## **COCKLE BAY PARK [SSD 7684] - DESIGN INTEGRITY PANEL - SESSION 11**

This letter has been prepared on behalf of the Design Integrity Panel (**DIP**) for the Cockle Bay Park State Significant Development (**SSD**), in relation to the design integrity process. This letter provides confirmation of the Panel's commentary on the design elements which required further resolution, in order for the development to be endorsed for design excellence. The feedback is based on the latest developed design, as presented by Henning Larsen on 4 August 2022.

Market Street / Civic Link connection - Landbridge Edge Protection - RTS

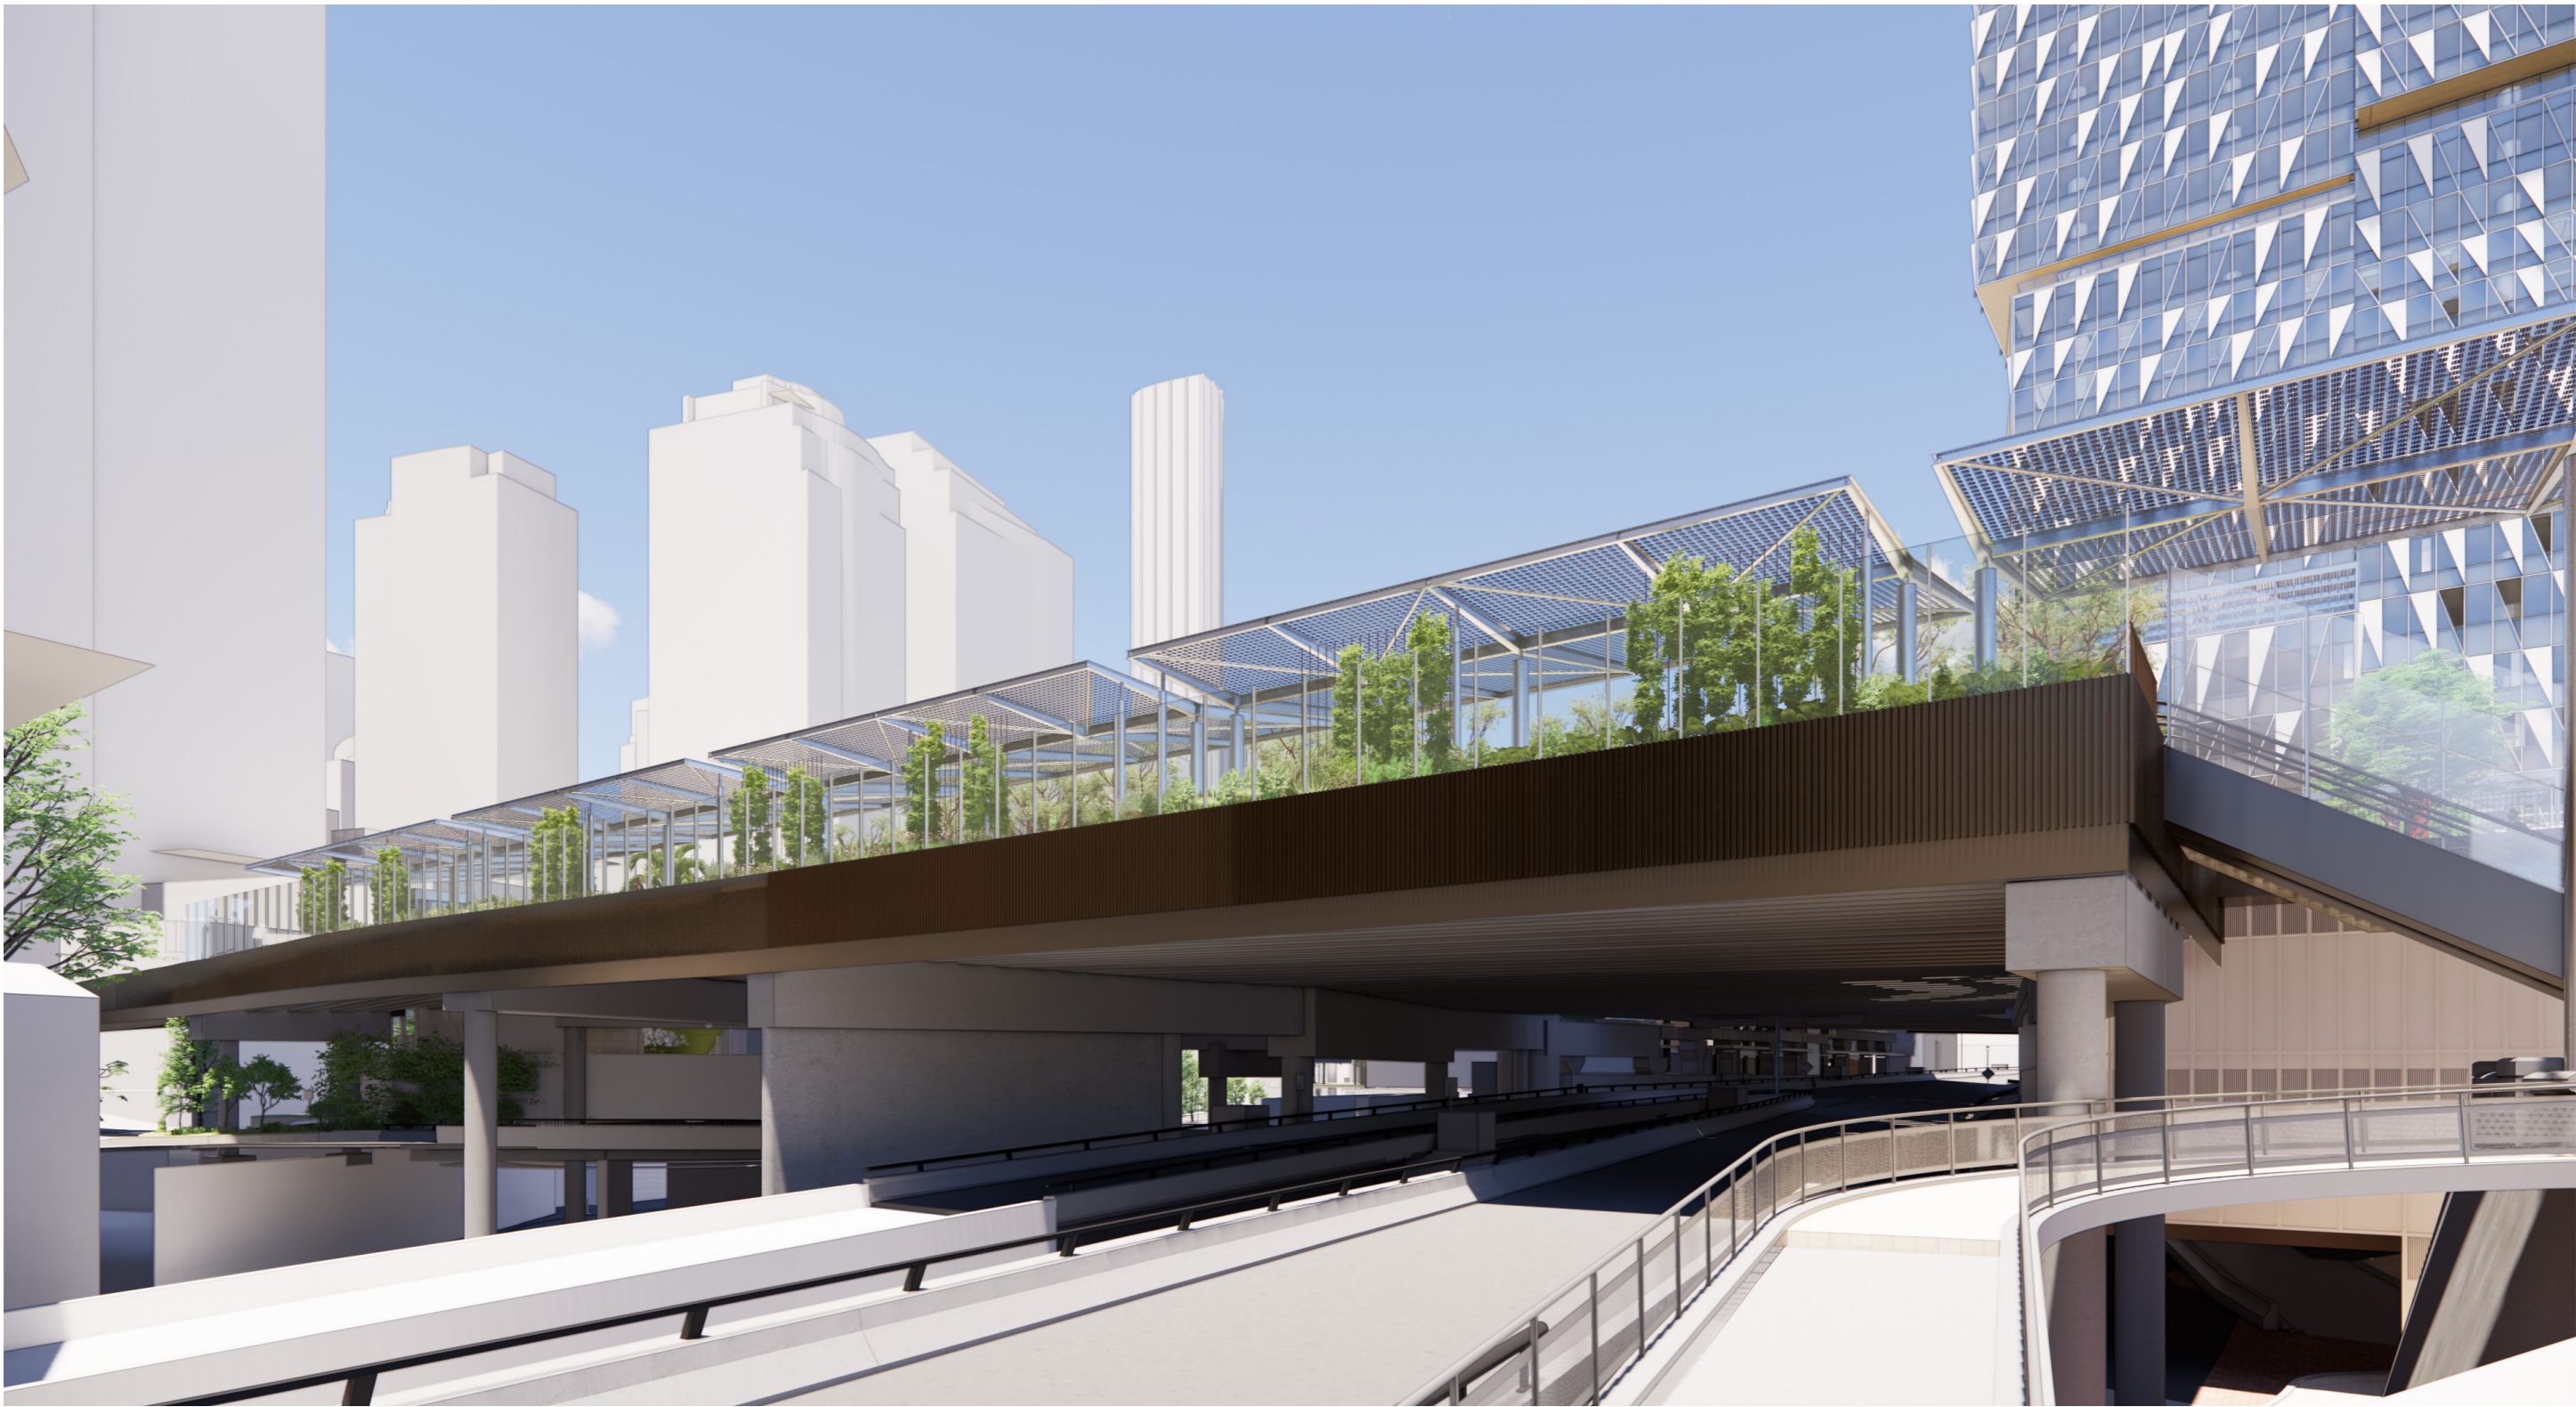
FOCUS AREA	COMMENTARY
<b>3. PUBLIC DOMAIN</b>	
<b>Market Street / Civic Link Connection</b>	<p><b><u>Stairs</u></b></p> <ul style="list-style-type: none"> <li>▪ At DIP Session 10, the Panel recommended that Henning Larsen review the position of the stairs / escalators in relation to the stand stone pylons, and in particular recommended that the design team confirm if this element can be inset into the land-bridged structure as far east as possible.</li> <li>▪ Henning Larsen presented three options to the Panel, illustrating the constraints associated with shifting the stairs / escalators to the east and the potential benefits of each of these options, with regard to improving the alignment with and visibility of the heritage pylons.</li> <li>▪ Slide 31 confirmed that, to achieve any sense of visibility of the heritage pylon, the resultant stair gradient would be 159:275mm and the headstock would need to be lowered by 200mm. This in turn introduced new issues.</li> <li>▪ The Panel has assessed the difference between a more generous stair and the visual impact of the heritage pylons. The Panel notes that the most highly valued view of the sandstone pylons is the view walking from Pymont to the City. The sideways view from a private development is less important. The Panel also notes that on balance, shifting the lift core east is the single most effective design change that exposes the heritage pylons and the bridge, as discussed in the below comments.</li> <li>▪ With consideration given to the impact on headstock, the visual geometry and the pitch of the stair, the Panel agree that moving the stair and escalator to the east changes the pitch of the stair and the resultant</li> </ul>

FOCUS AREA	COMMENTARY
	<p>outcome places the pedestrian permeability and comfort at risk in comparison to moving the lift tower.</p> <ul style="list-style-type: none"> <li>▪ The Panel agree that the current design, as presented on slide 29, presents the most desirable outcome as it provides for a generous new public stair and retains the alignment of the substructure. Given that the most benefit is gained from moving the lift, the Panel’s view is that the visual impact is negligible whether the stair moves or otherwise and the priority is to retain pedestrian permeability.</li> <li>▪ In acknowledging the detailed nature of this commentary, the Panel encourages the team to continue to refine the design geometry relationship between the stairs and escalators, as viewed from Pymont Bridge, so that it presents as one unified, simpler element.</li> </ul> <p><b><u>Headstock</u></b></p> <ul style="list-style-type: none"> <li>▪ The Panel support all design development relating to the headstock and notes the significant architectural improvements arising from this. The Panel have no further comments.</li> </ul>
